Application No: FG/101/25/PL
Site Address: 4 South Drive Ferring BN12 5QS
Description of works: Erection of replacement dwelling together with reprofiling of the site and installation of new boundary to front of site. This application is in CIL Zone 4 and is CIL Liable as a new dwelling.

Thank you for your internet representation made on 13th August 2025 which has been recorded as an objection with the comments as follows:

PROPOSED REAR AND SIDE
ELEVATIONS

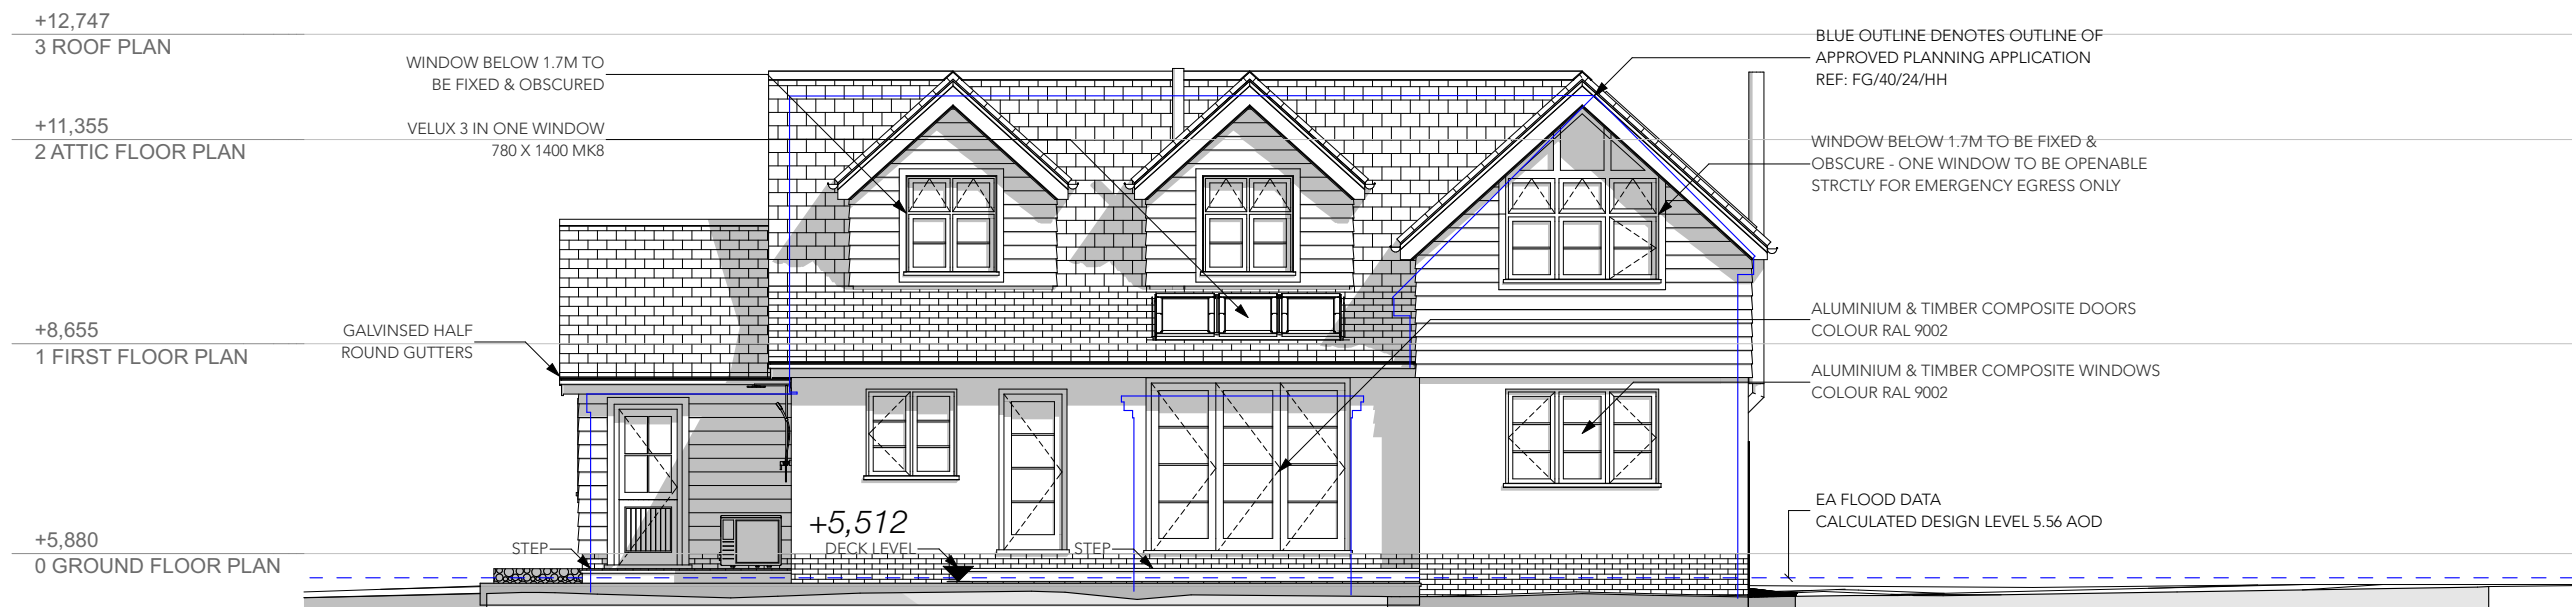
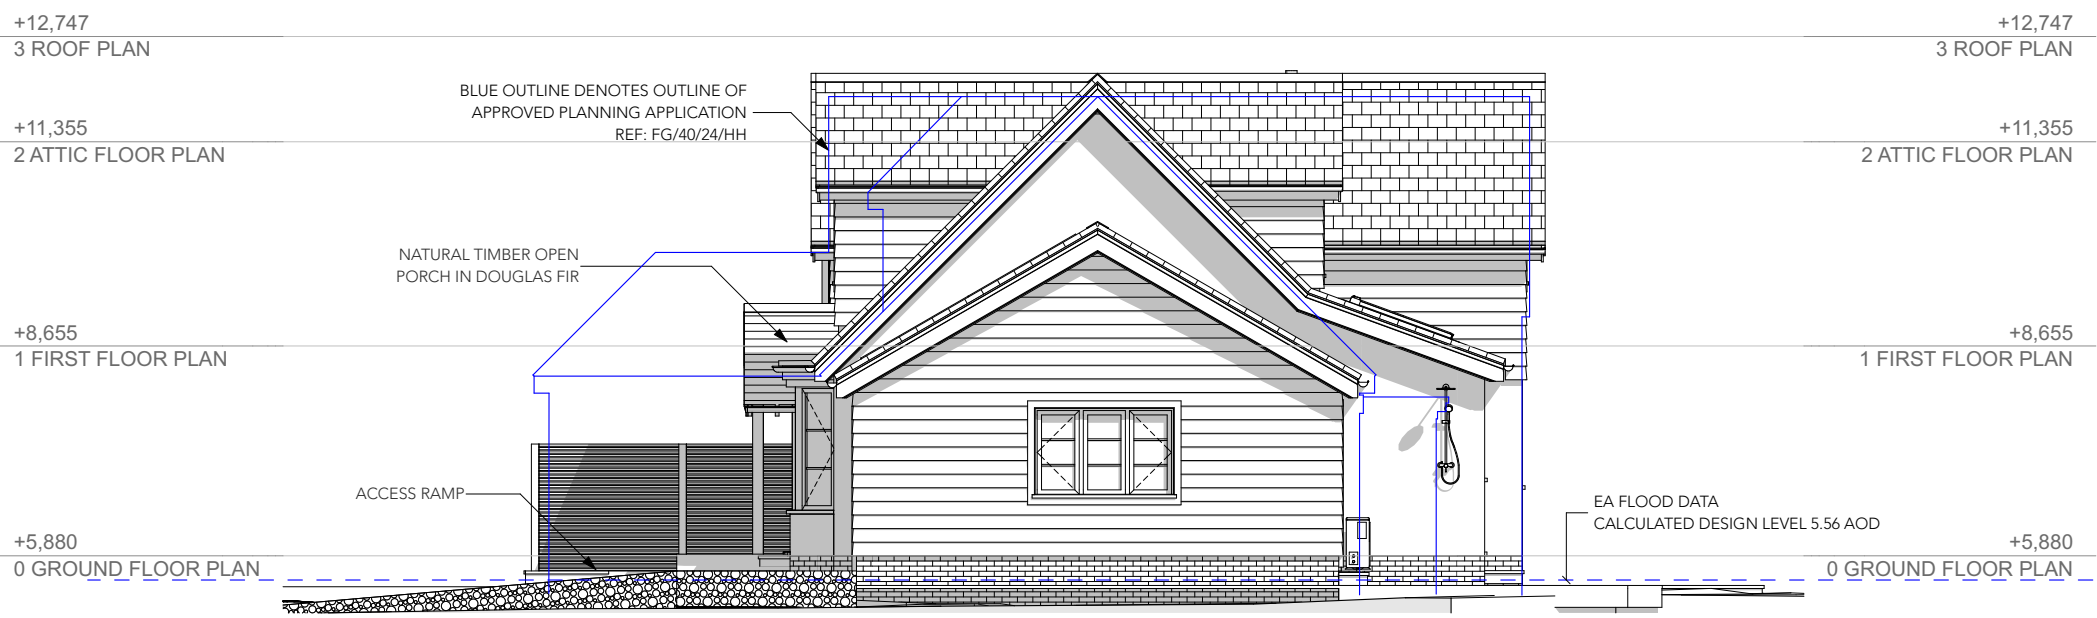
A larger footprint and significantly greater mass than the existing dwelling on the site which will be imposing in relation to the traditional properties either side with some loss of amenity space.
The proposal will create overlooking of neighbouring rear gardens from the rear first floor windows which does not currently exist, impacting on the privacy of neighbouring rear garden amenity spaces.
